**Consultation Response from KC,
Trees**

2023/93097 Land adjacent to, 196 Wakefield Road, Earlsheaton, Dewsbury, WF12 8AH

Erection of 5 dwellings (class C3) and ancillary office accommodation, formation of associated access, car parking and landscaping

Date Responded: 09/04/2024

Block B - Ground Floor Plan  
Scale 1:50

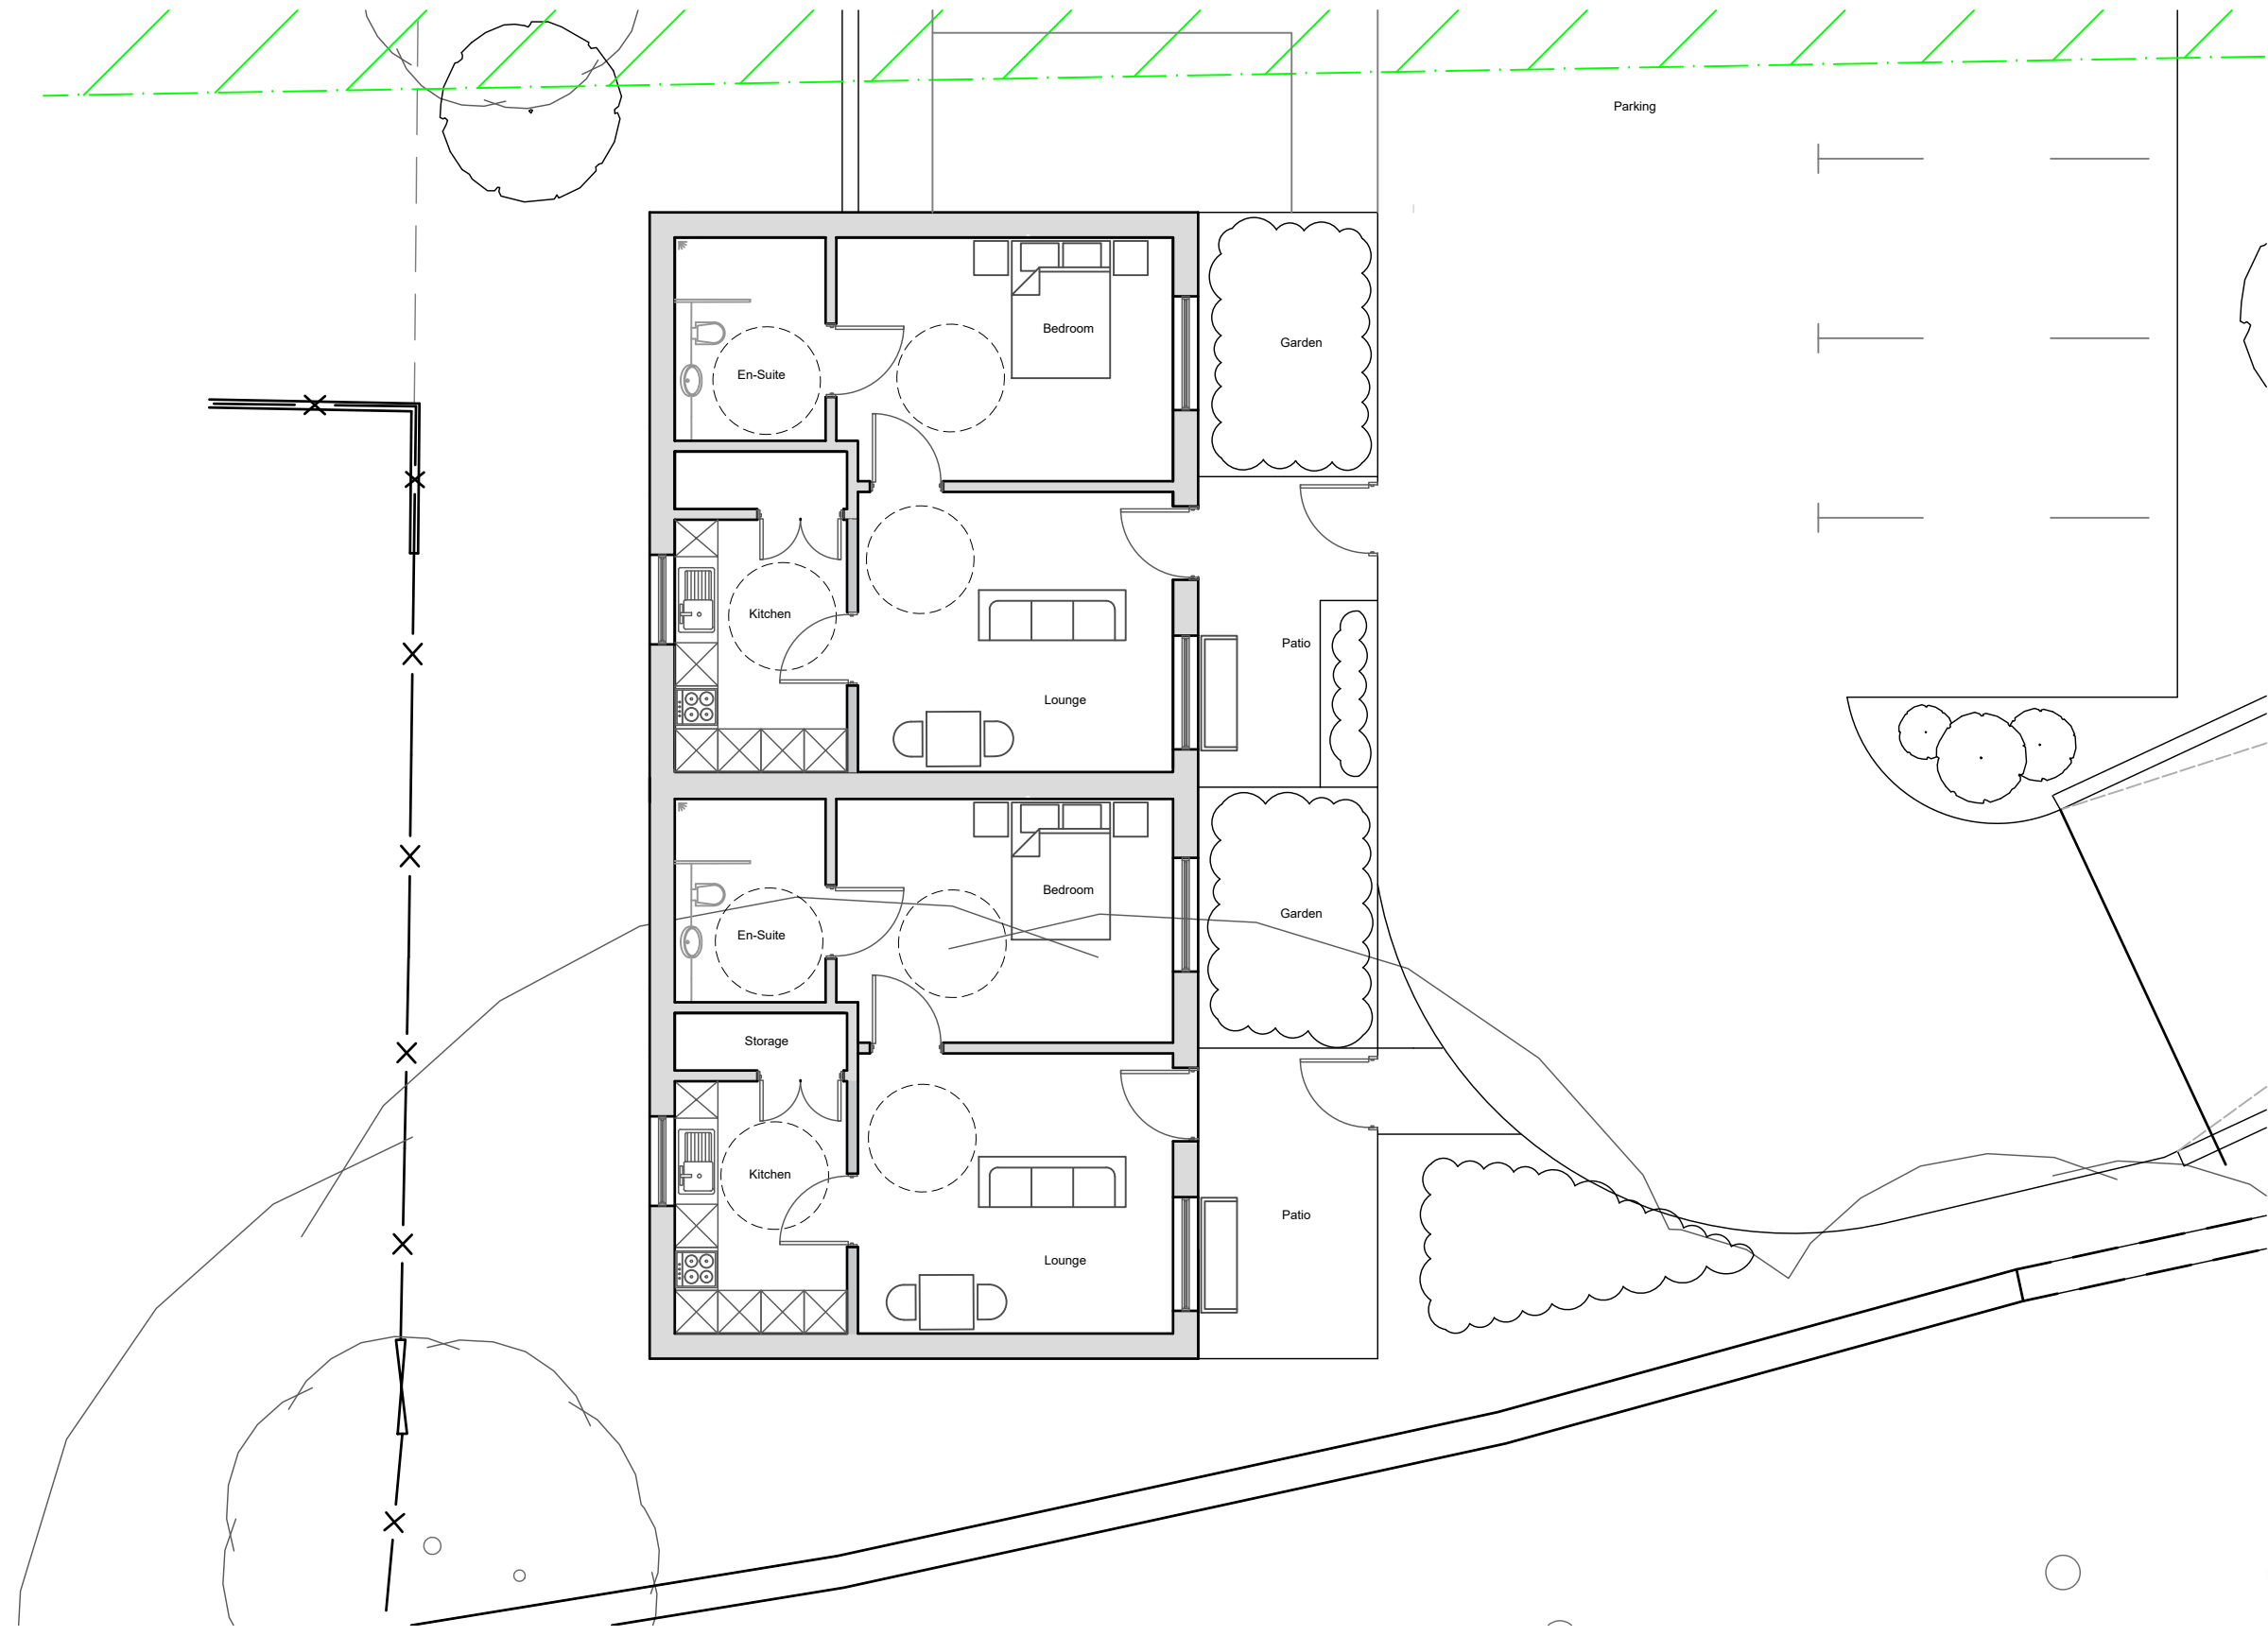
Block B is proposed under the canopy of T6 (Ash). Ash can lose a lot of twigs and smaller branches in wind and more frequently have canopies with deadwood within them.

It is foreseeable the falling deadwood/general detritus and apprehension of the occupants (i.e. the tree is large and overhangs) will lead to pressure to prune the tree in order to reduce the overhang and/or perceived risk of harm from falling twigs and branches.
